Memorandum

To: Robin Proebsting
From: Ruji Ding
Re: SUB20-002
Date: February 19, 2021

I've reviewed the submittal package and have the following conditions of approval:

CHESHIRE SHORT PLAT

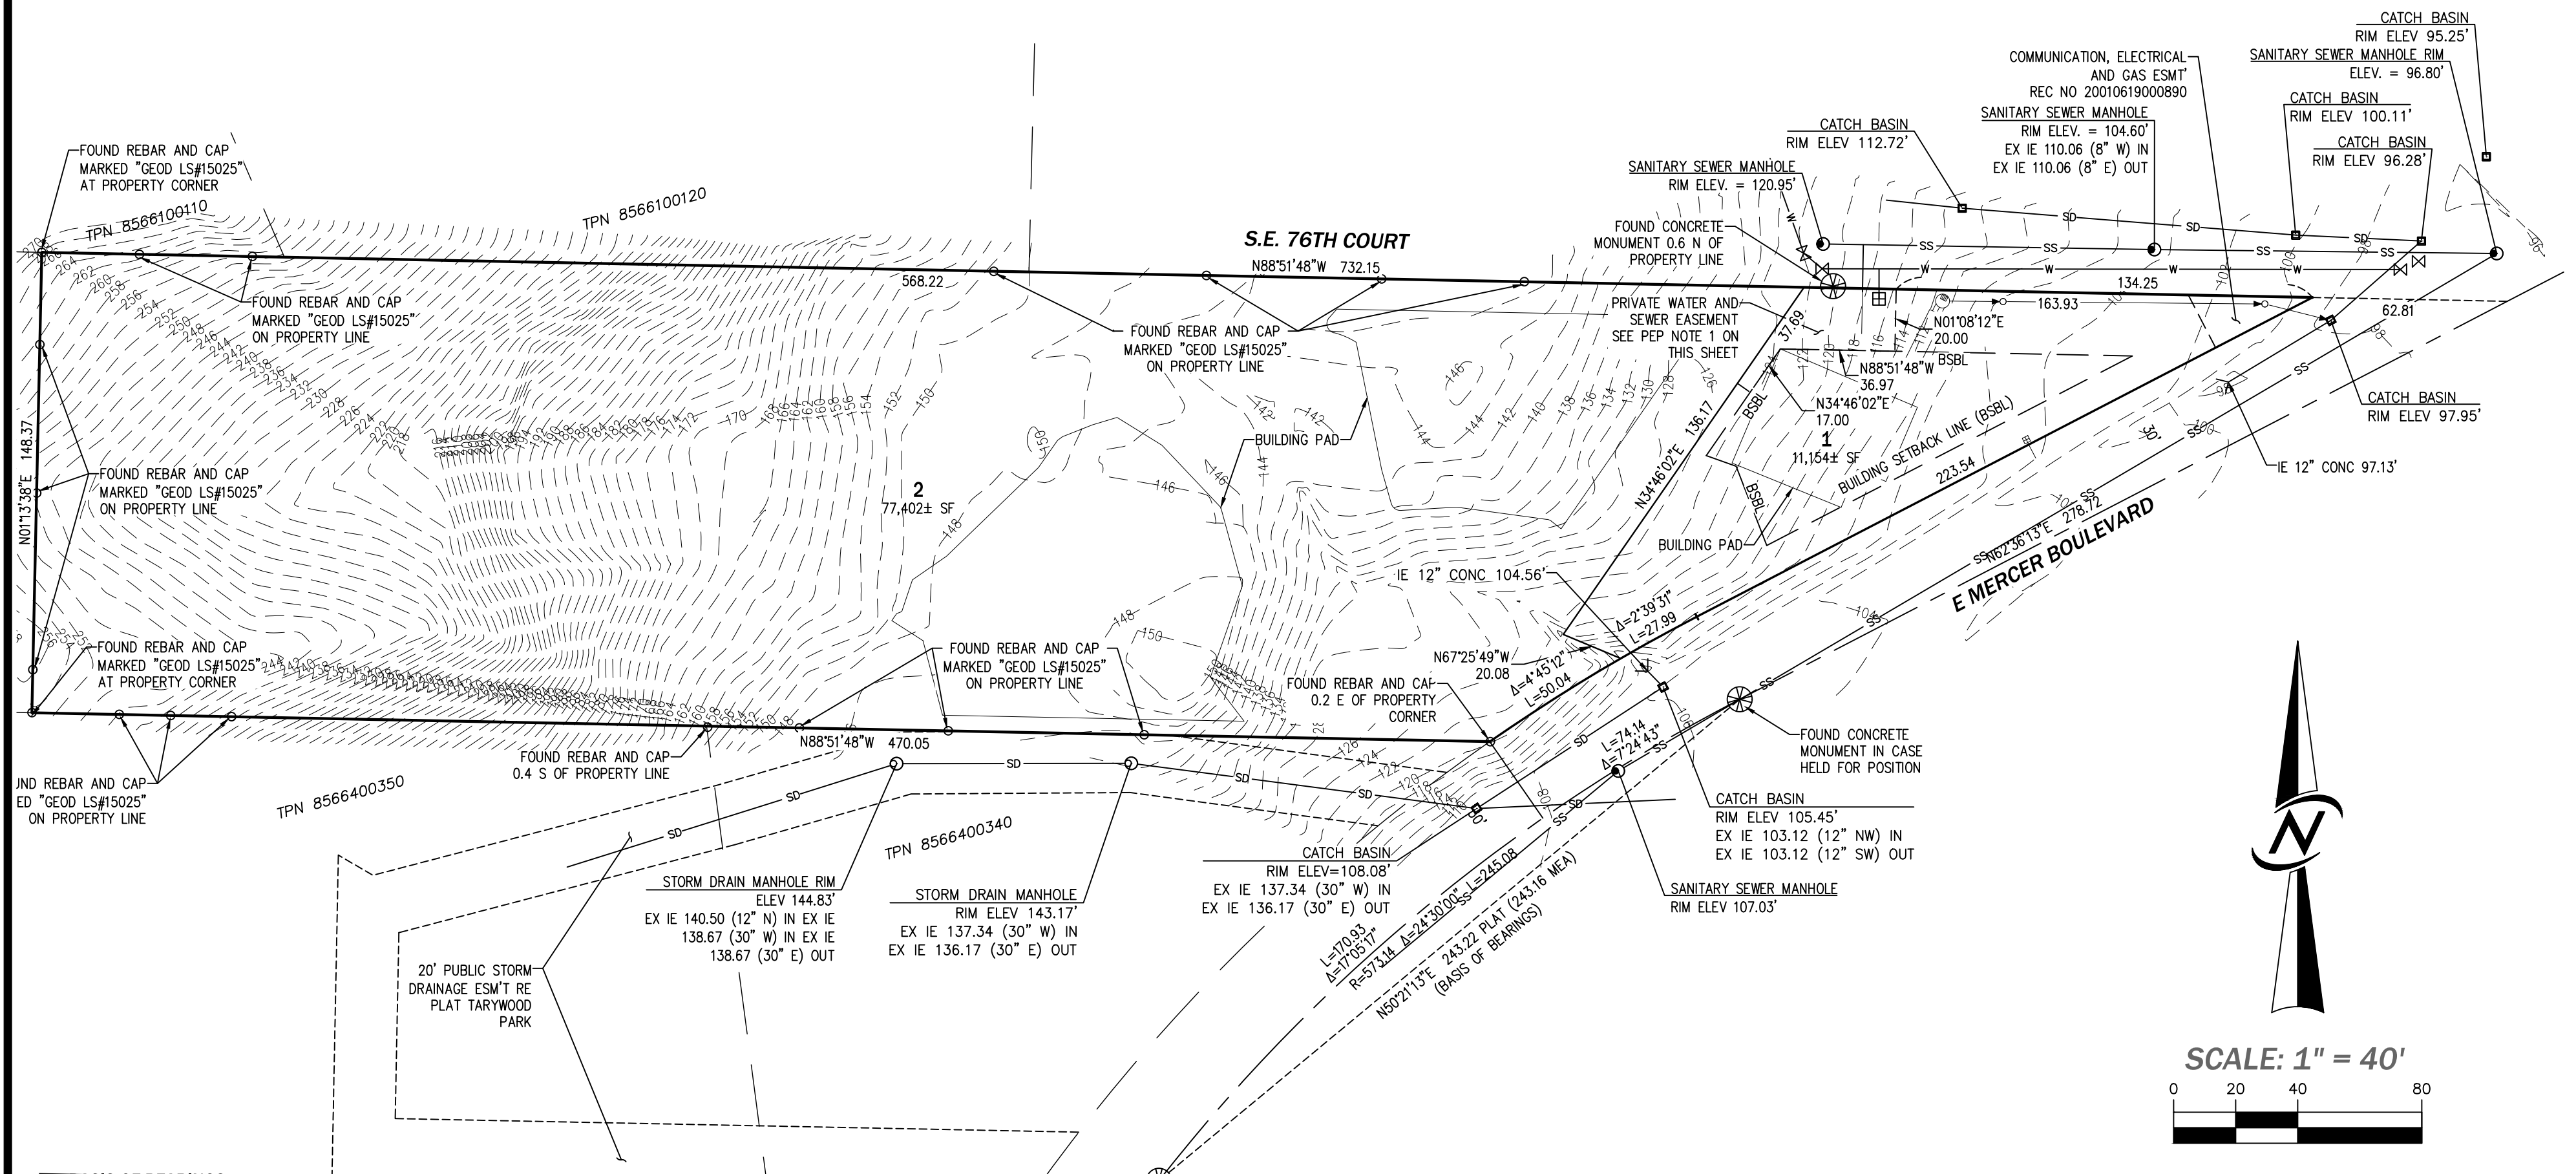
1. Show all the existing and proposed easements on the final plat. Clearly distinguish all public easements from the private easements. The private utility easement and public utility easement shall not be combined.

2. Easements for utilities and storm drainage facilities shall be depicted on the face of the Final Plat. Language which indicates joint rights and responsibilities of each lot with respect to all utilities and roadways shall be shown along with individual lot Joint Maintenance Easement Agreements (where applicable) for all shared usage and filed with the King County Recorder and noted on the final plat. The easement notation shall indicate whether the easement is public or private, existing or proposed.

3. The Final Plat shall be prepared in conformance with Title 58 RCW and Surveys shall comply with Chapter 332-130 WAC. Submit using Mercer Island's datum and tie the plat to at least two monuments.

4. A City of Mercer Island title block for approval signatures (Planner and City Engineer) shall be provided on the final plat along with the designated Short plat number.
